**22/03873/F**

**Land North And Adjacent To Mill Lane Stratton Audley**

**Installation and operation of a renewable energy generating station comprising ground-mounted photovoltaic solar arrays and battery-based electricity storage containers together with a switchgear container, inverter/transformer units, Site access, internal access tracks, security measures, access gates, other ancillary infrastructure and landscaping and biodiversity enhancements.**

Berkshire, Buckinghamshire and Oxfordshire Wildlife Trust

Client
JBM
Project:
Padbury
Drawing Title:
Site Layout Plan - 1 of 4
Drawing No: 1051745-ADAS-XX-XX-DR-PL-8001
Scale: 1:1000 at A1
Drawn by: A.F. Date: 26/07/22
Checked by: D.H. Date: 26/07/22

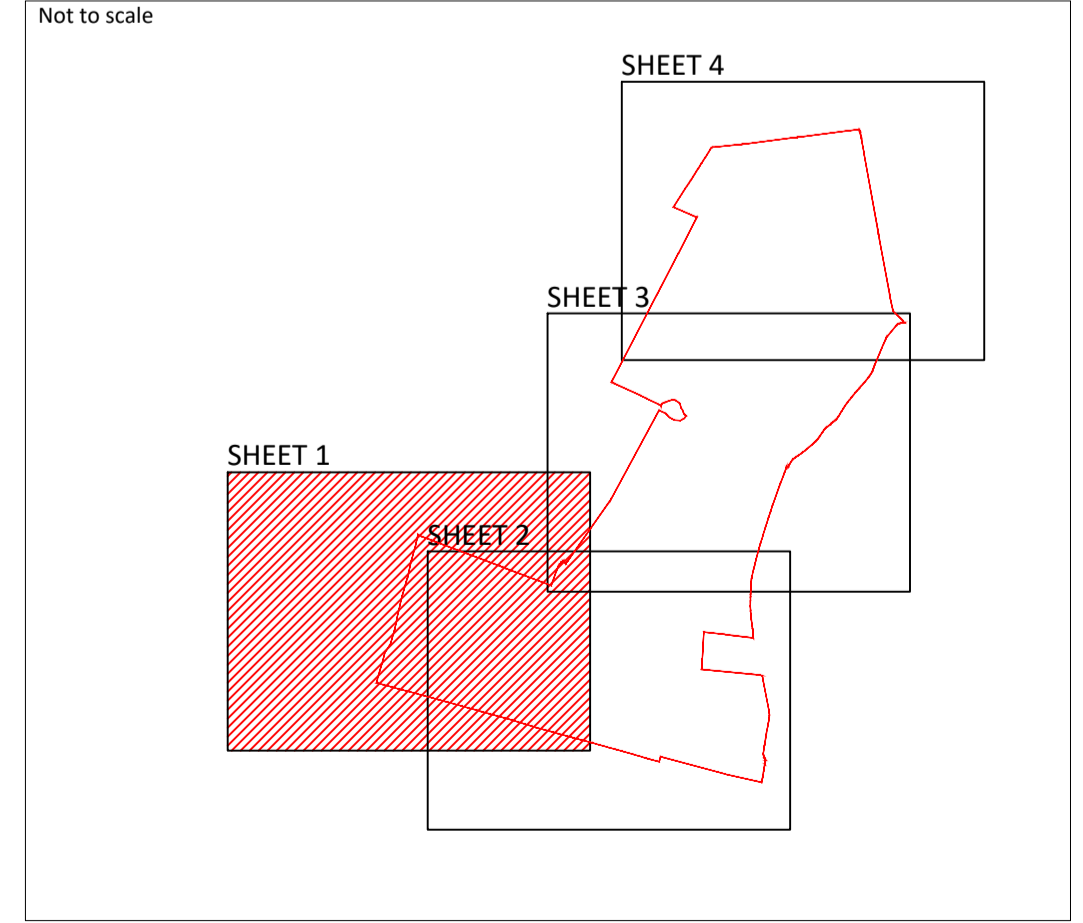
As an absolute minimum we consider that the entire field closest to the Oldfields Copse ancient woodland/proposed CDWS should not have any solar panels and instead be used for the creation and management of high-quality species rich wildlife habitat to provide a buffer between the ancient woodland and the fields with solar panels. For more details see section 4 below.

One possible measure which might be taken in order to mitigate the impact on wildlife would be to use the most northerly field adjacent to Oldfields Copse ancient woodland/proposed CDWS as a buffer area keeping it free from solar panels and managing it for the benefit of wildlife, including the breeding and wintering bird species which favour open vista habitats such as lapwing and skylark (see paragraph 2 above). This would also provide the buffer we consider necessary for the bird, bat and invertebrate species using the ancient woodland habitat at Oldfield Copse (see paragraph 1 above).

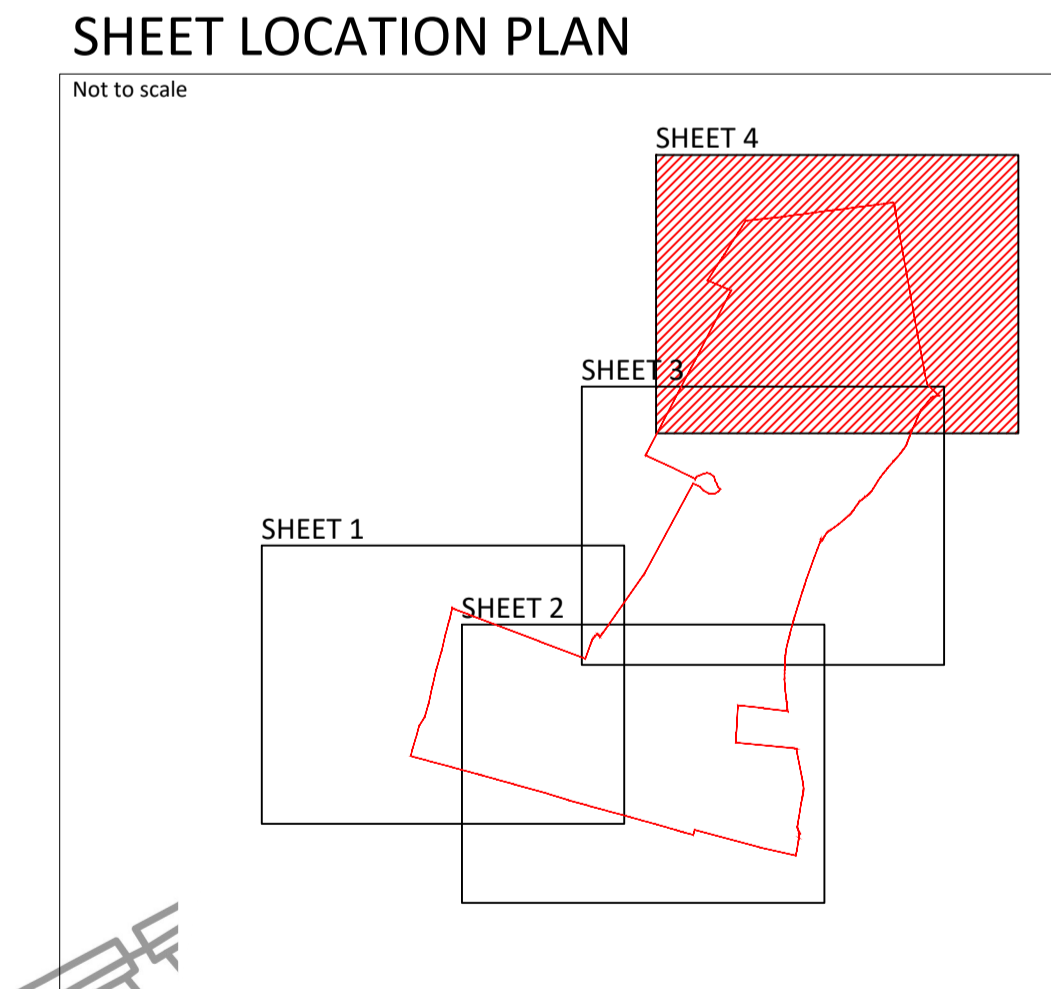
In particular we are concerned that the seed mix (Habitat Aid ‘Grazing Meadow Seed Mix’ or similar) to be sown within the solar array fence which will cover the vast majority of the site (49.27 of 58.05 hectares) is a grazing mix rather than a wildflower seed mix and contains a high proportion of perennial ryegrass. It therefore may not achieve the predicted other neutral grassland in moderate condition within five years (see paragraph 4.2.4 of the applicant’s BNG statement) especially as most of this area will be shaded by the solar panels.
